Subject: Confidential: Enterprise Works, off Long Lane, Honley

DRAWING TITLE  
EXISTING AND PROPOSED SITE PLAN

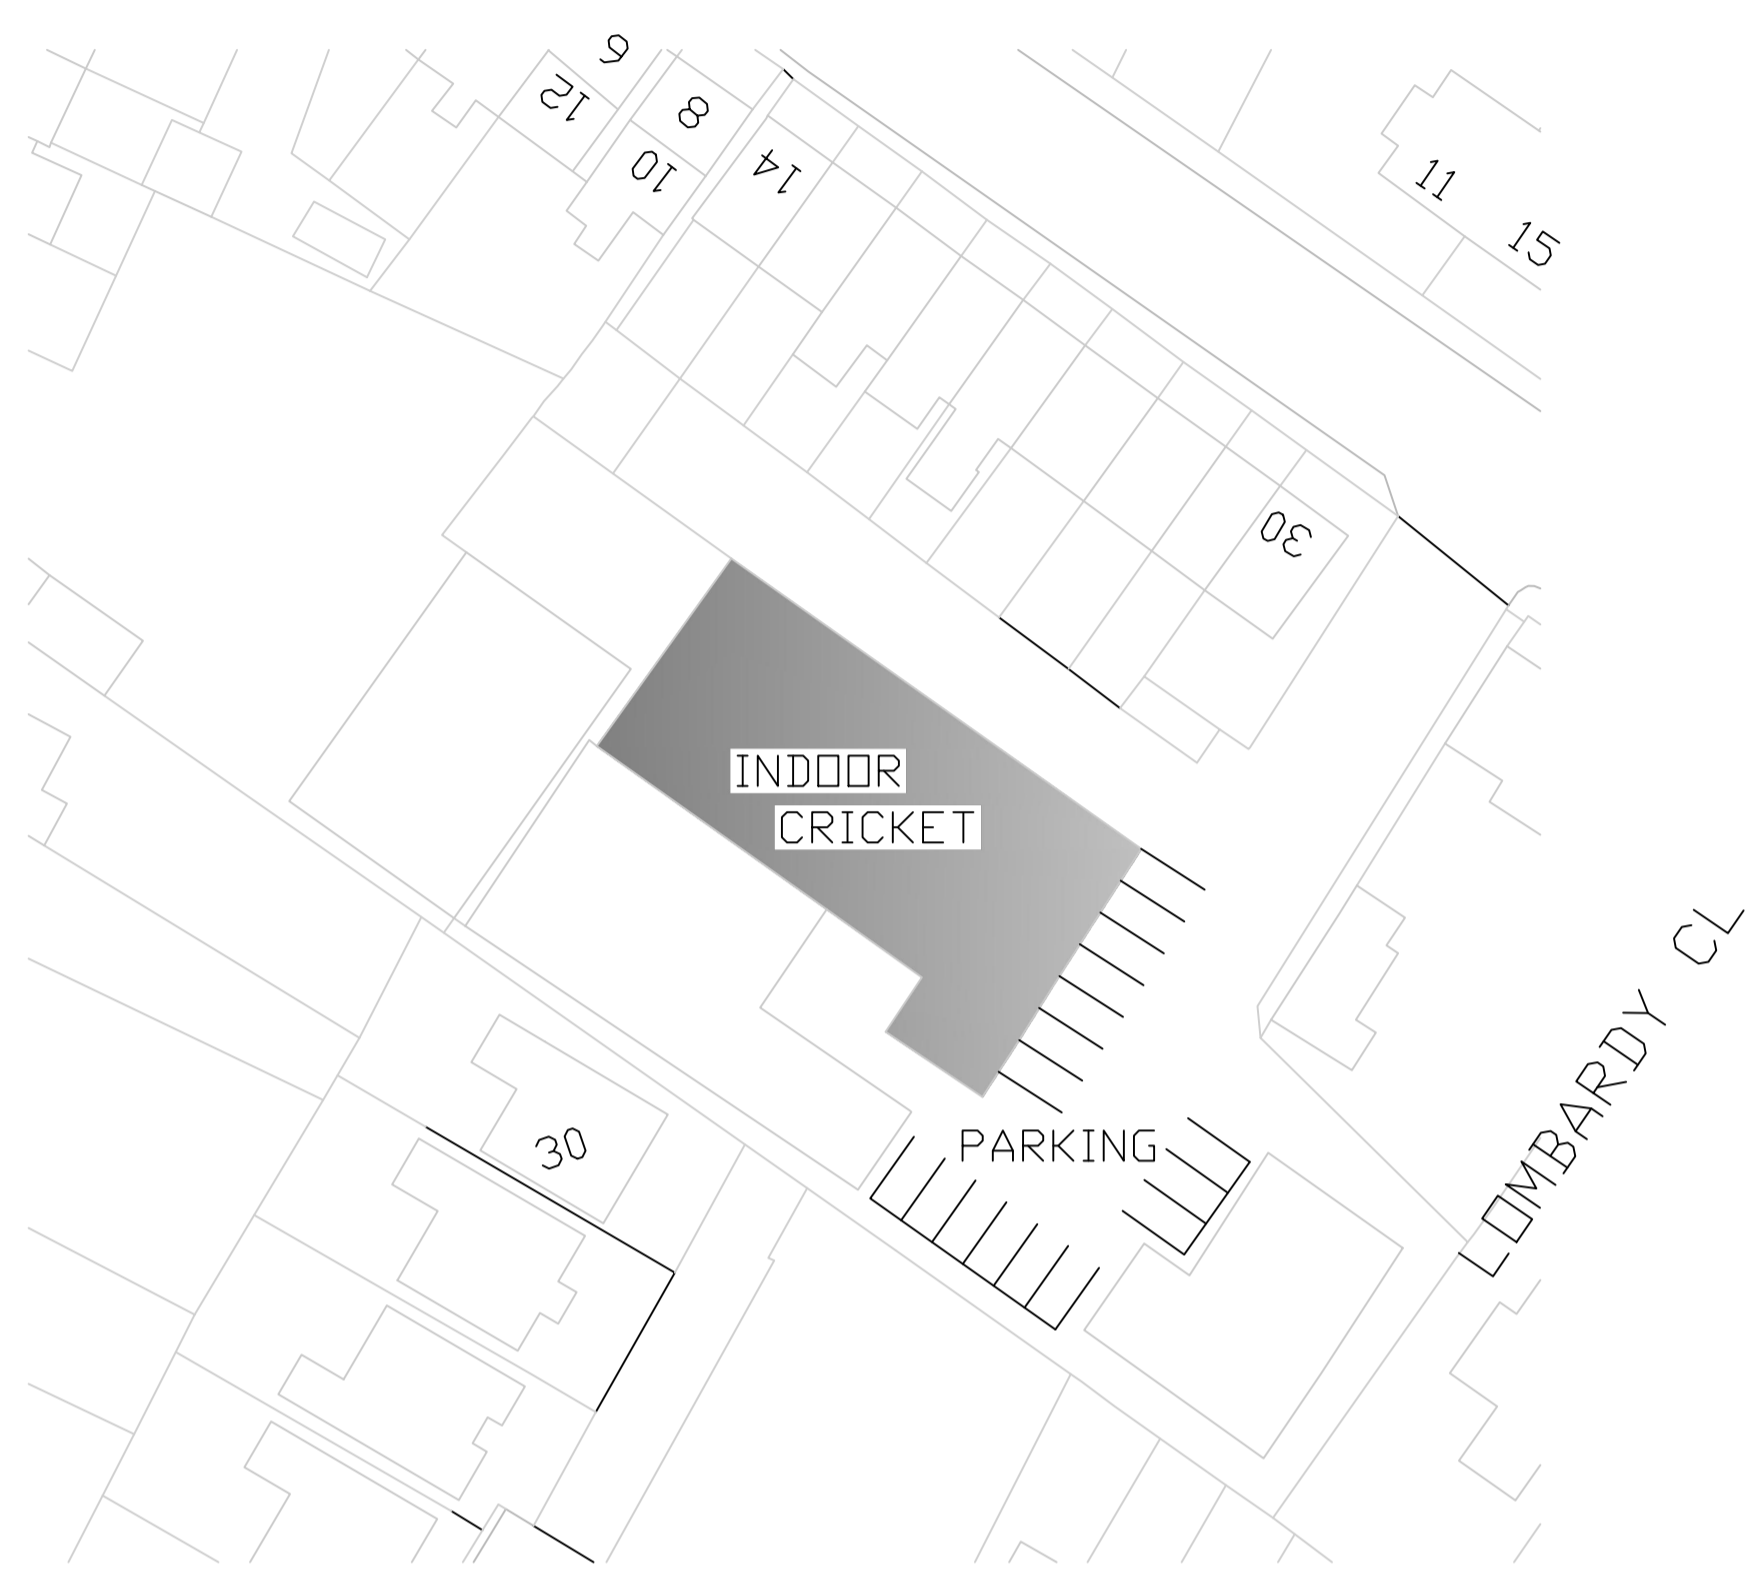
1. The application location plan covers land which is not within [redacted] ownership and is used by the neighbouring commercial property. Effectively this reduces the parking provision by six car parking spaces. Please see the attached location plan which shows in green the area not within his ownership. I suggest you ask [redacted] to amend his location plan to only show his area of land.

2. The land within his ownership only has parking for 10 cars four of these spaces currently have containers on them are these to be removed for car parking because if they remain this reduces the parking provision down to six spaces.

3. The application is for only part of the buildings it is shown from the proposed
site plan that this unit is to have sole use of all the car parking spaces. What is to happen to the remainder of the commercial space and where are the occupants of the other unit to park their vehicles and receive deliveries along with turning areas for deliveries.

I advise you ask the applicant to amend his location & site plan and for more information regarding how many vehicle movements per hour there will be on site and I strongly suggest there is not enough parking for this use. I am also of the opinion that the site due to its close proximity to residential properties is not suitable due to noise issues.
